From: Hugo Butterworth <[REDACTED]>
Sent: 07 May 2021 11:50
To: Amber Willard
Subject: Re: aw/93/21/clp

I am just looking over your application at 35 Willowhale Avenue. **AW/93/21/CLP**

Plan showing the floor area of the existing and proposed conservatory 1:100

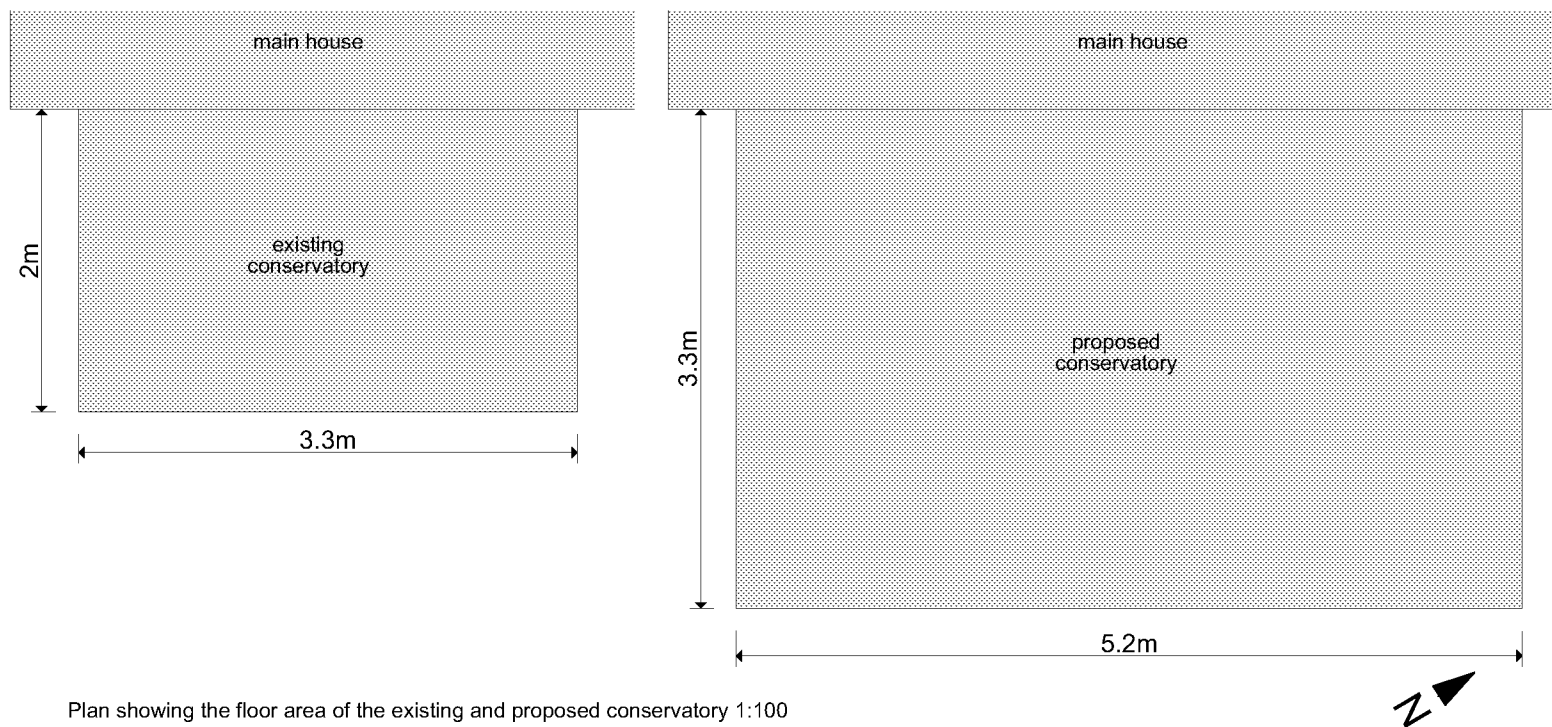
- The total proposed height of the front addition (with the increased roof)
- The total proposed height of the rear conservatory
- The height of the eaves of the rear conservatory

The height of the rear conservatory will be 3.7-3.9 m high and will not exceed 4m

The height of the eaves of the conservatory will be between 2.1 and 2.3m.
